TO: CHAIR AND MEMBERS OF THE ZONING BOARD OF APPEALS
FROM: MARGE SCHMUCKAL, ZONING ADMINISTRATOR
SUBJECT: 38 TORRINGTON AVENUE, PEAKS ISLAND, 084-S-006 – IR-2
DATE: JULY 1, 2009

As per instructions after the decision of Superior Court, I have reviewed the existing application for expansion using section 14-436(a) of the Land Use Zoning Ordinance which states:

TOTAL HEIGHT OF  
PROPOSED STRUCTURE  
31'9" (< 35'-0" MAX)

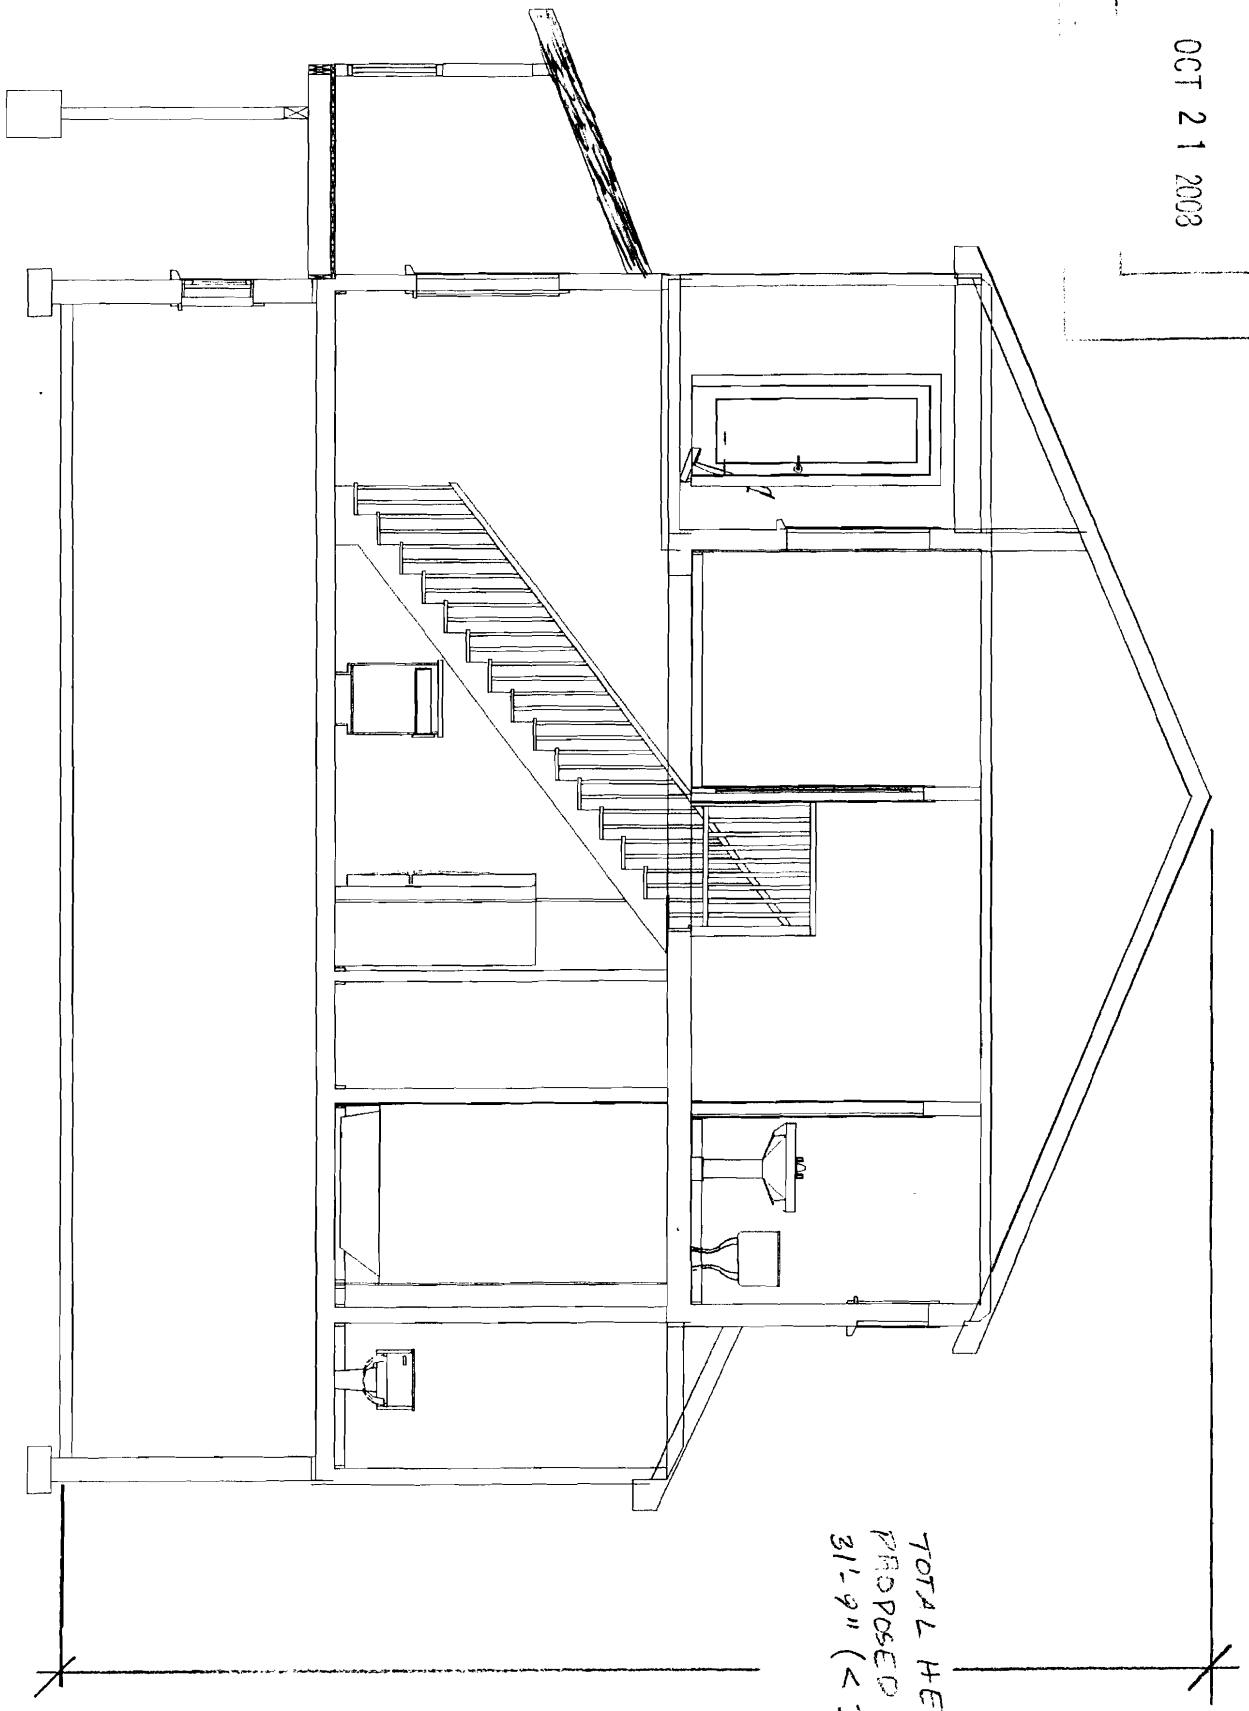
Mr. William Childs of Horizon Builders, Inc. also submitted a sketch showing the original roof configuration overlaid upon the new construction (drawing “B”). That sketch shows that the head room of the original and new structure. 14-436(a) allows the permitted expansion to be enough for minimum height for habitable space. The plans

show that the height from unfinished floor to the average ceiling height is 7' 8 3/8". The new space is providing the minimum height required under the building code which is 7'. It is noted that the ordinance regulates the minimum height and not the maximum height. It does not say that the ceiling shall be no more than the minimum required. This third task is being met.

Section 14-436(a) finally states that the expansion limit and method, achieving at least the minimum height for habitable space, must also preserve the existing roof configuration to the maximum extent possible. I have use the submitted sketch to show what the effect of two full dormers without a change to the roof configuration would look like. The structure would essentially become a flat roof building with the original pitch roof configuration gone. See figure "C". This final bar in the ordinance allows for the exiting roof configuration to be maintained. The word "configuration" is a key word. It does not say that the roof must remain flat if there is an addition of two full dormers. Therefore, I believe that it is allowable, and probably encouraged, to add a new roof above the dormers if it matches the existing roof configuration to the maximum extent possible. Looking at both sketch submittal "B" and the before and after pictures "D", I do not believe the new roof line preserved the existing roof configuration to the maximum extent possible. The trusses have a different pitch and a taller depth from the bottom cord to the top of the peak. The roof's final design does not meet the wording of 14-436(a).
